HERBATA DATA CENTRE, NAAS - RESPONSE TO REQUEST FOR FURTHER INFORMATION ("RESPONSE TO RFI") FROM KILDARE COUNTY COUNCIL

ADDENDUM TO CHAPTER 4 DESCRIPTION OF THE PROJECT AND
NEED FOR THE PROJECT

NI2615
01
June 2025

DWG NO: 22217-RKD-ZZ-ZZ-DR-A-1400

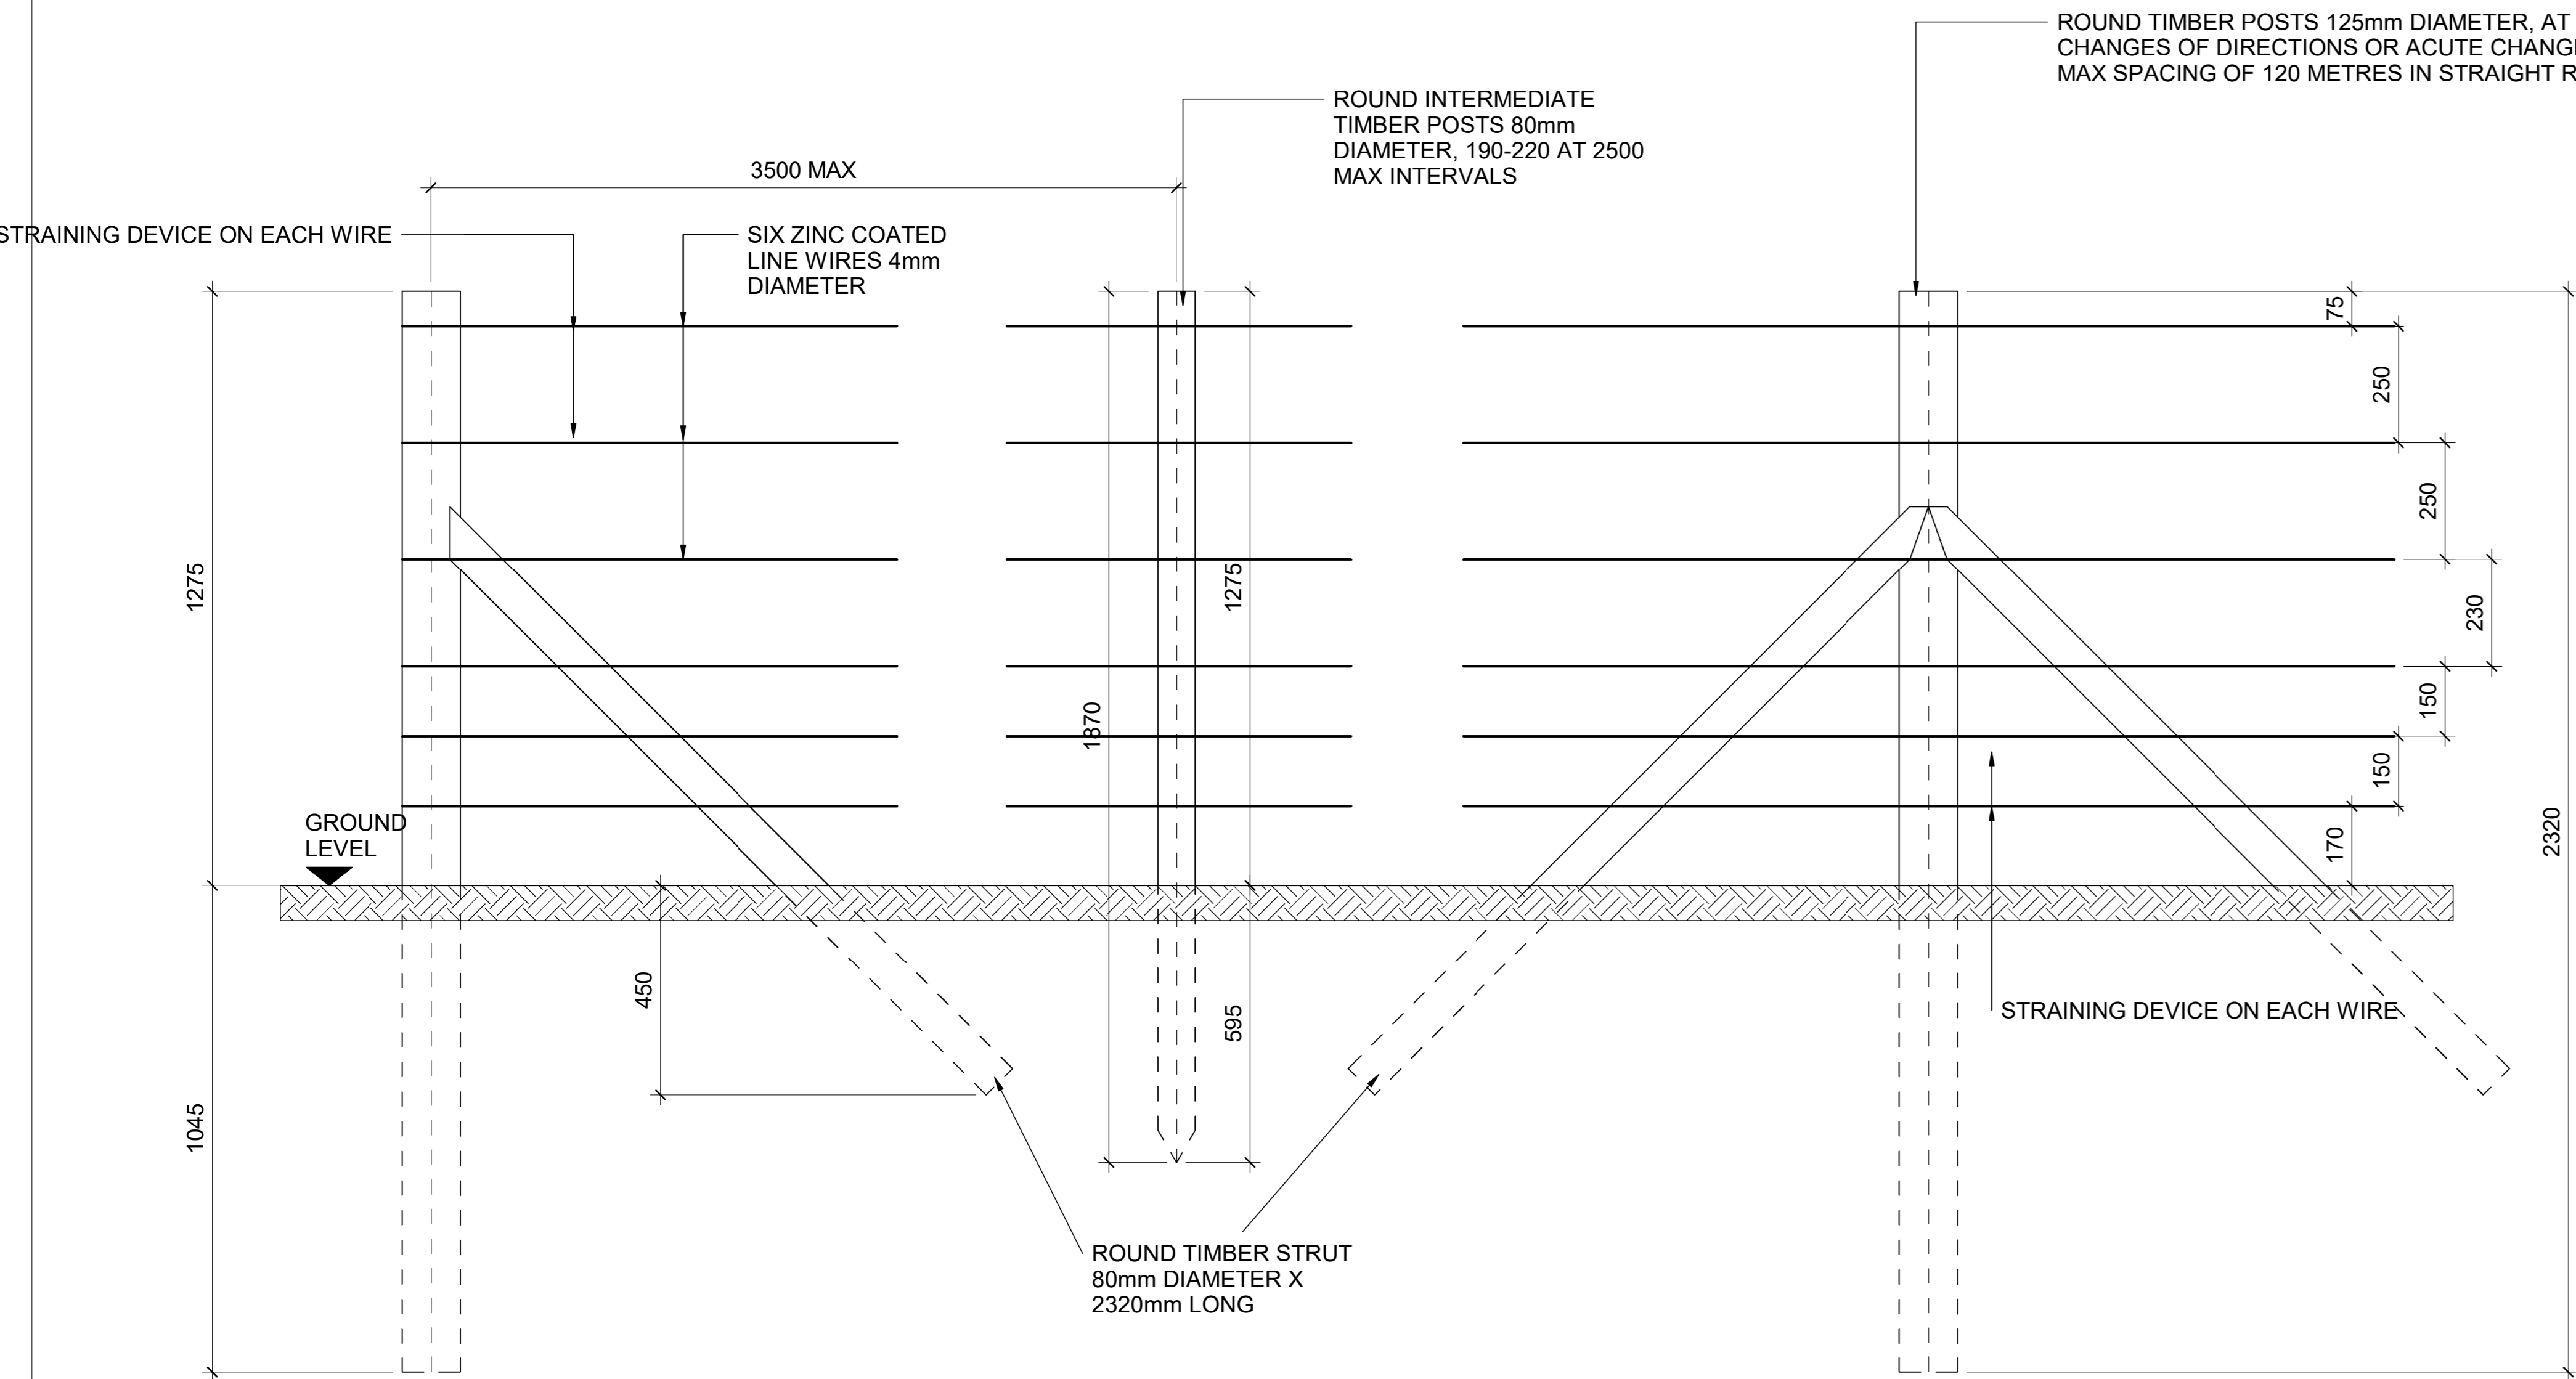
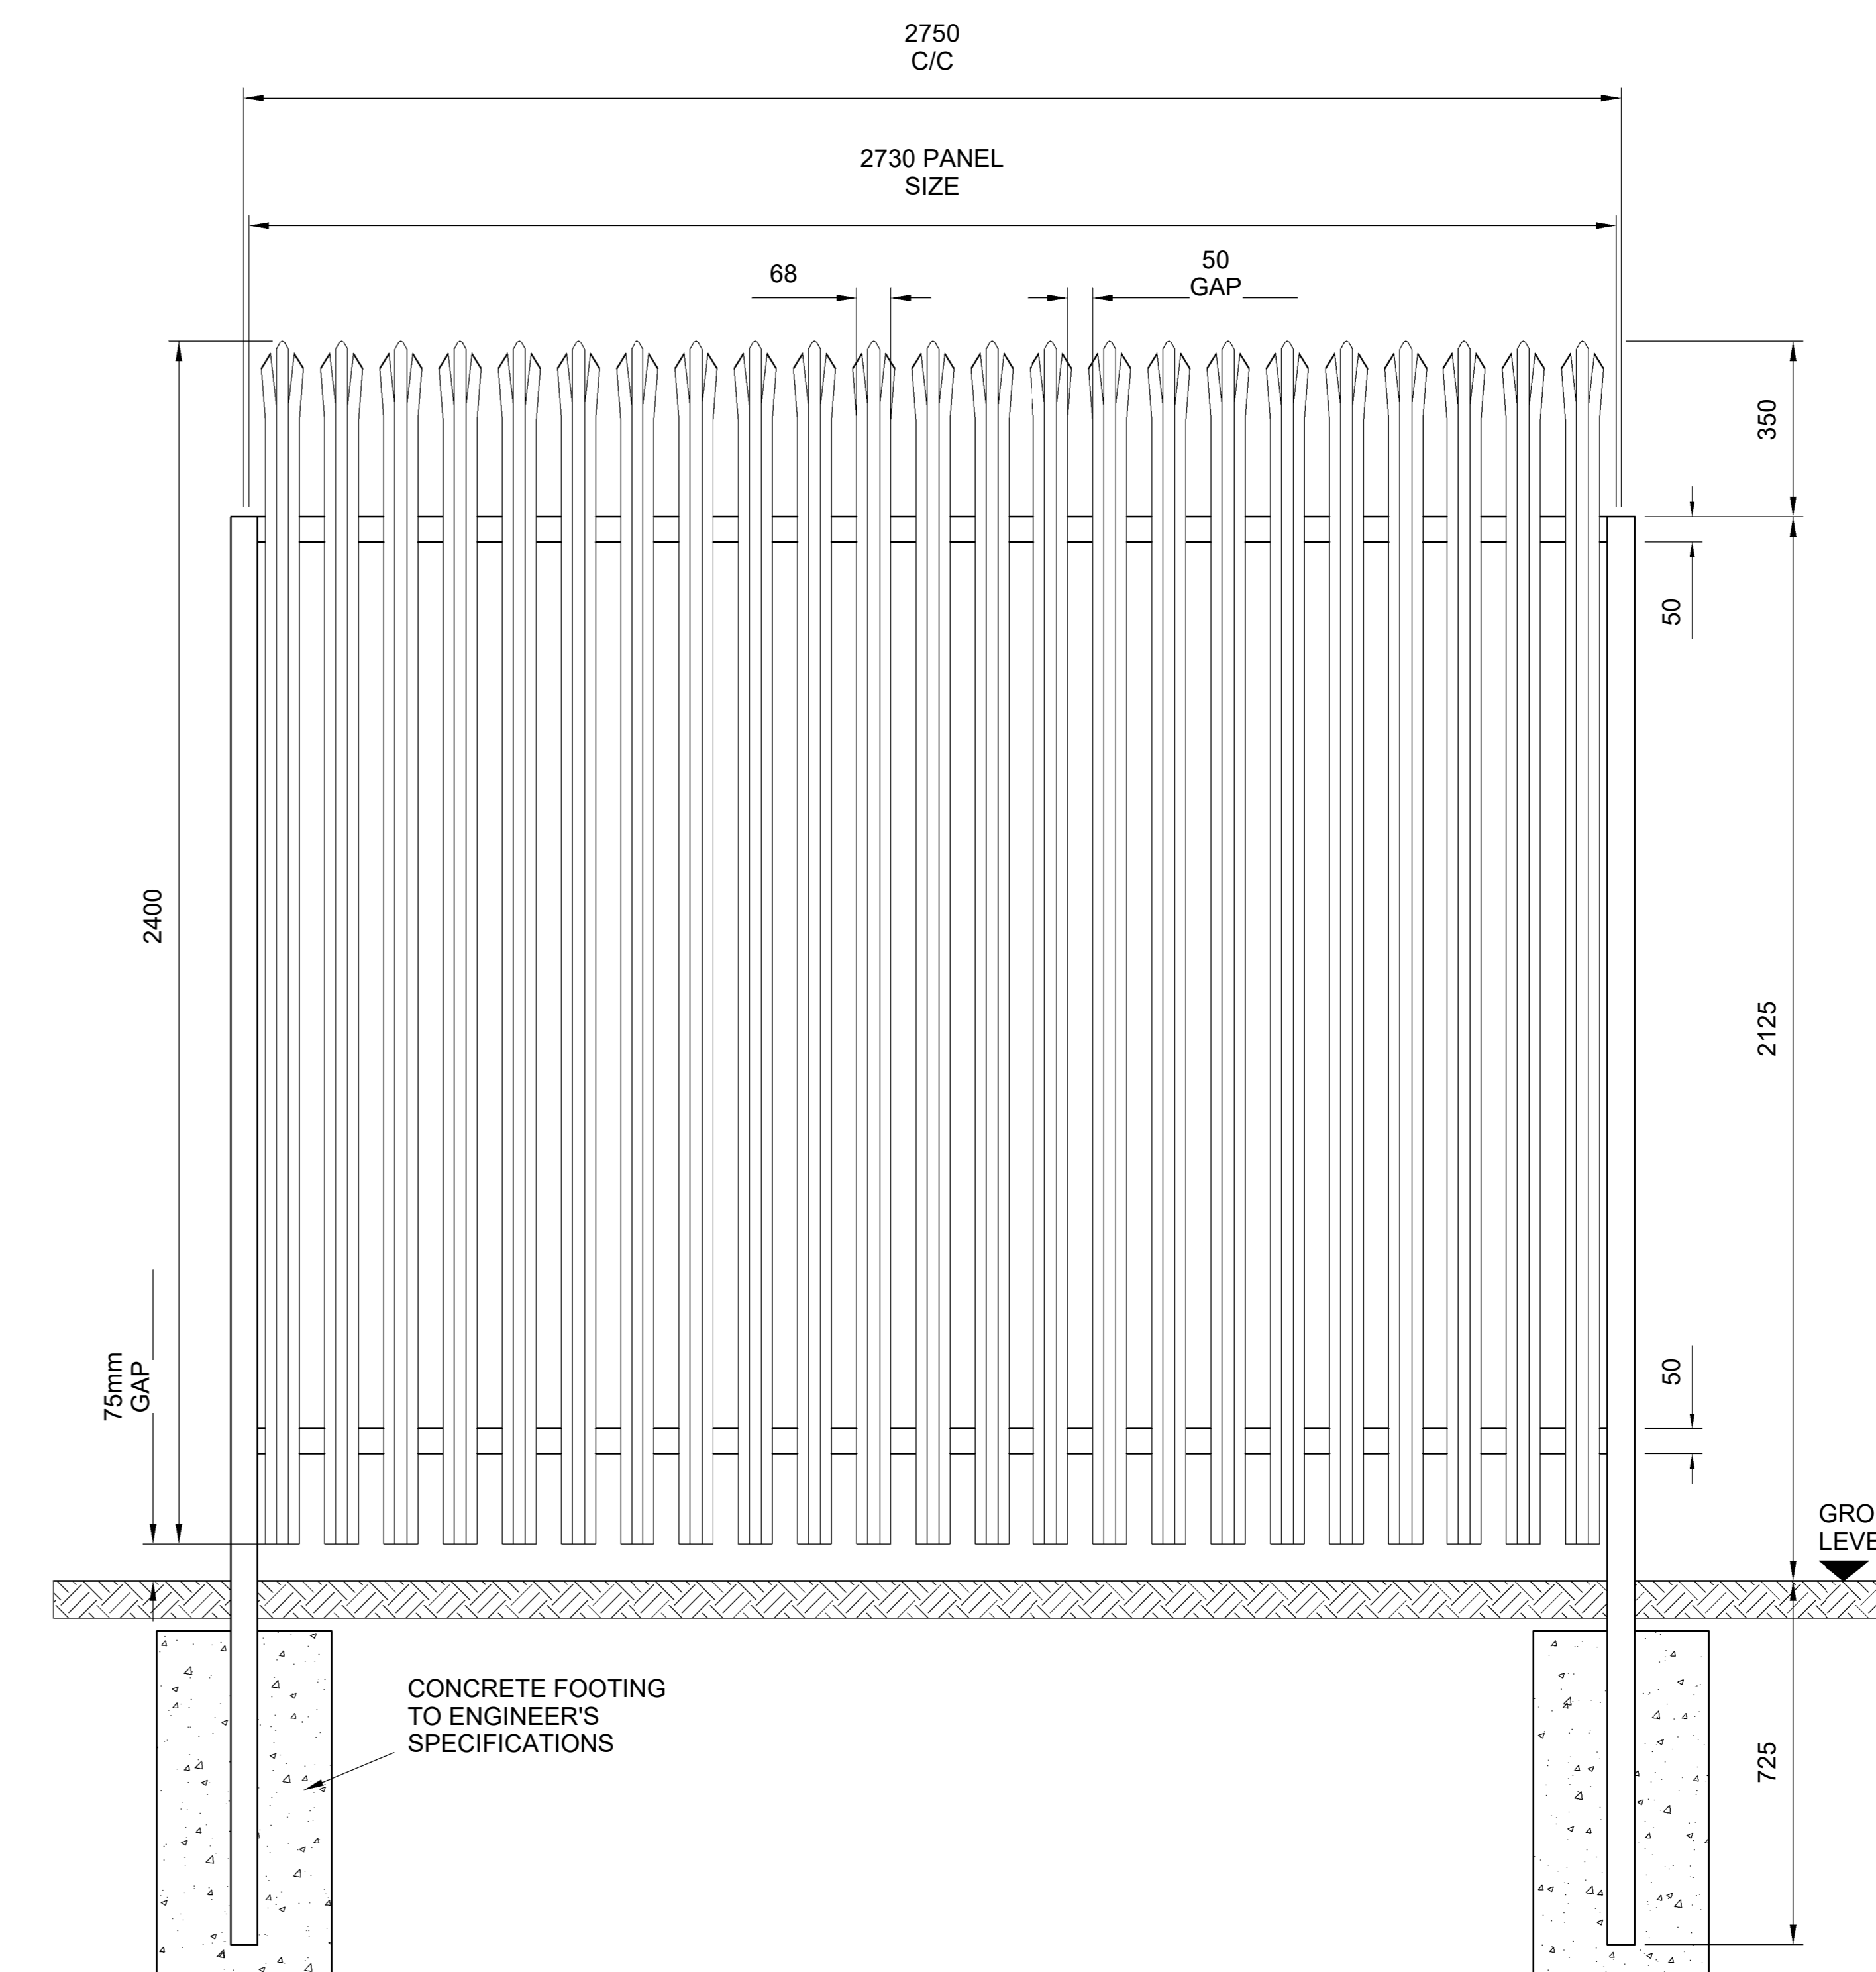
In consideration of the request for inclusion of a fencing arrangement *to allow for wildlife access and passage through the site*, an amendment has been made to the proposed Landscape Masterplan to include mammal passes in fences throughout the full extent of the site. The number, location and dimensions of the mammal passes was established following engagement between the project ecology and landscape team. The inclusion of the mammal passes has not required changes to the submitted landscape planting proposals.

Mammal passes are proposed at locations throughout the site including all *perimeter* fences and *internal* fences within the site (for example around each Data Centre building). A gap at the foot of the proposed fencing, of 500mm (width) x 200mm is determined sufficient for all potential mammal species and should ensure access and passage throughout the site. There are no proposed amendments to the overall height, materials or layout of the proposed fencing.

Figure 4.10 below (extract of drawing number BSM-ZZ-ZZ-DR-L-0311 Landscape Boundary Treatments Plan) illustrates the location of the mammal passes; Figure 4.11 below (extract of drawing number 22217-RKD-ZZ-ZZ-DR-A-1400 Proposed Boundary and Fence Details) illustrates the detailed dimensions of the fencing.
